27 April 2018

620.17901 L01 - v0.3 20180427 Traffic RtS.docx

Mirvac Projects Pty Ltd  
6001 (Bay 6) and 7006 (Bay 7)  
2 Locomotive Street  
Eveleigh NSW 2015

## **Locomotive Workshop Redevelopment | SSD 8157 and SSD 8449 Traffic and Transport Response to Agency Submission**

REVERSE IN FROM WEST

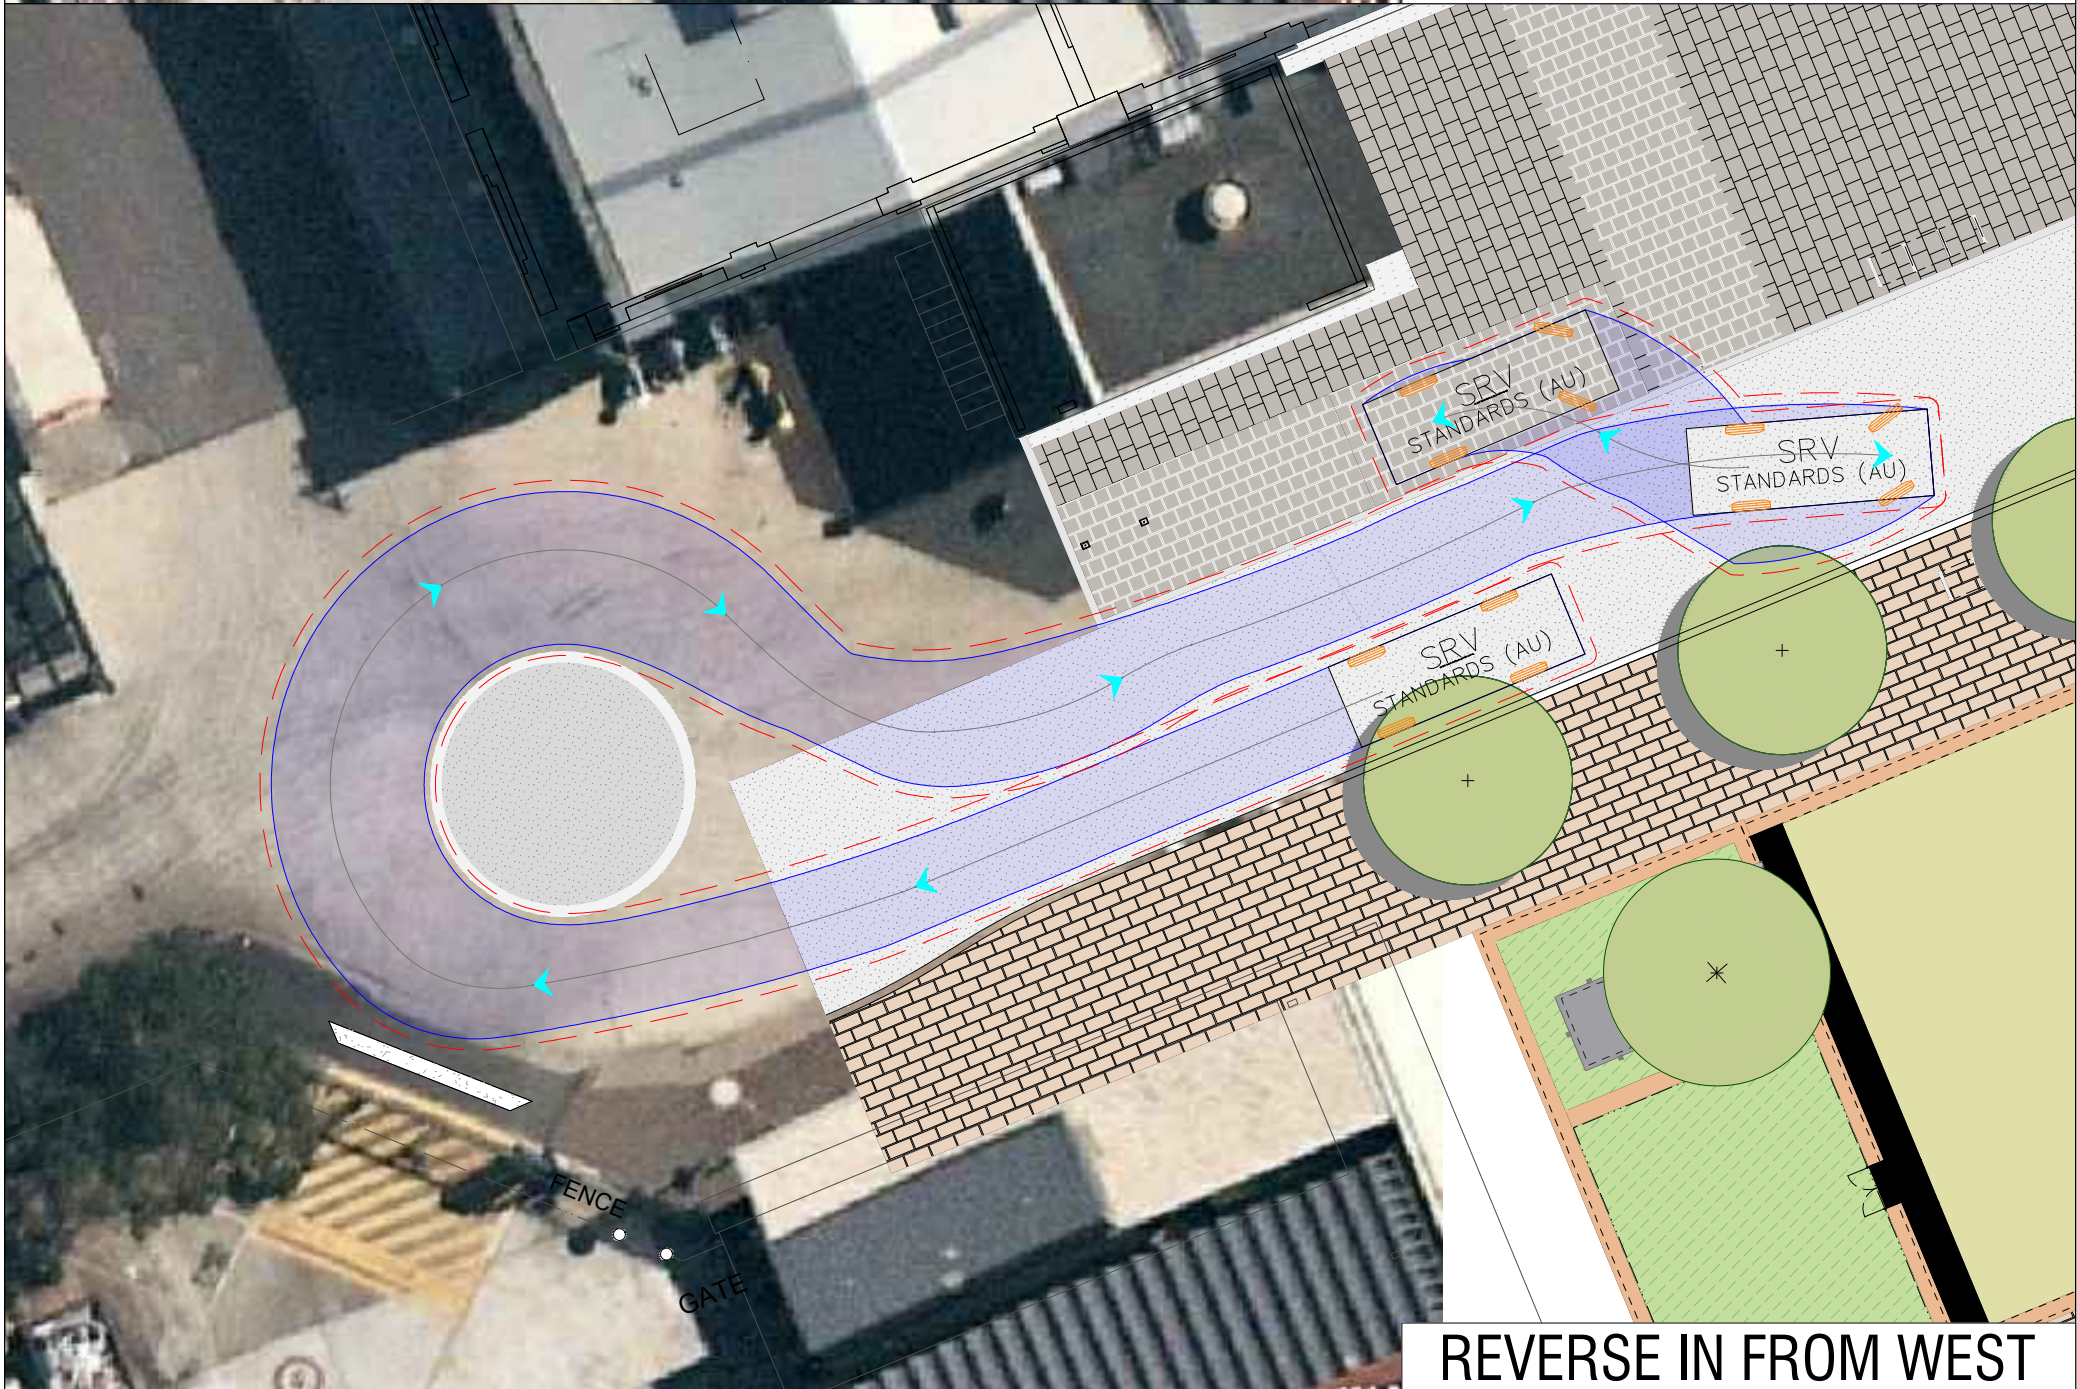
Within Innovation Plaza, trucks will enter in a forward gear, stop, and reverse into the subject loading dock. **610.17901.SK09** and **SK09B** show these arrangements for the RCV and LRV respectively. Potential conflicts between pedestrians and trucks in Innovation Plaza can be categorised as occurring in three segments when trucks:

Conflict type 2 involves the truck reversing into the proposed loading dock from a stopped position in Innovation Plaza. Whilst the specifics should be resolved as part of a Loading and Access Management Plan that can be imposed as a consideration of approval; this manoeuvre is considered acceptable based on the following:

The swept path plans confirm that one of the existing trees in Innovation Plaza will have to be removed to facilitate entry/exit to the loading dock. The impact on the remainder of the trees including partial conflict with canopies is limited. Additional detail is included in the arborist's Tree Removal and Pruning Application prepared by Hancock Consulting.

The previously submitted development plans have been revised such that the flexibility and internal scale of the service area and loading dock is improved. **610.17901.SK09** and **SK09B** show the swept path requirement for the two larger design vehicles manoeuvring within the loading dock area.

- Servicing movements can occur outside peak pedestrian demand periods
- Innovation Plaza incorporates physical landscaping and street furniture that has been designed to emphasise the desired walking route being central to Innovation Plaza. Devices and treatments are selected to passively shift pedestrians away from walking in close proximity to the loading dock entry
- Truck will be travelling at low speed and will be fitted with reversing claxons
- Pedestrians occupying the potential conflict area inside the truck turning circle will be visible to the driver from his driving position
- Drivers are likely to be regulars to the site and will be familiar with the locale and behaviours
- All users will have good observational sight distance to one another.

Of particular note, the service area can now accommodate at least two large trucks concurrently, i.e. two trucks can enter, stop/service, and exit clear of one another irrespective of their arrival and departure order. Concurrent loading/refuse collection was not previously possible with reference to the swept path plans prepared by GTA as part of the original SSDA.

The SLR swept paths confirm that the design vehicles can manoeuvre to, within, and from the service area with 0.6m clearances measured from the truck body. This clearance is double the 0.3m specified by AS2890.5 for low speed truck manoeuvring. Furthermore, the swept paths indicate that there is even more clearance or 'breathing space' available beyond the 0.6m clearance envelope. This is especially the case where trucks travel past the Davy Furnace and other heritage and building elements. The internal loading dock arrangements accord with that specified in AS2890.2.
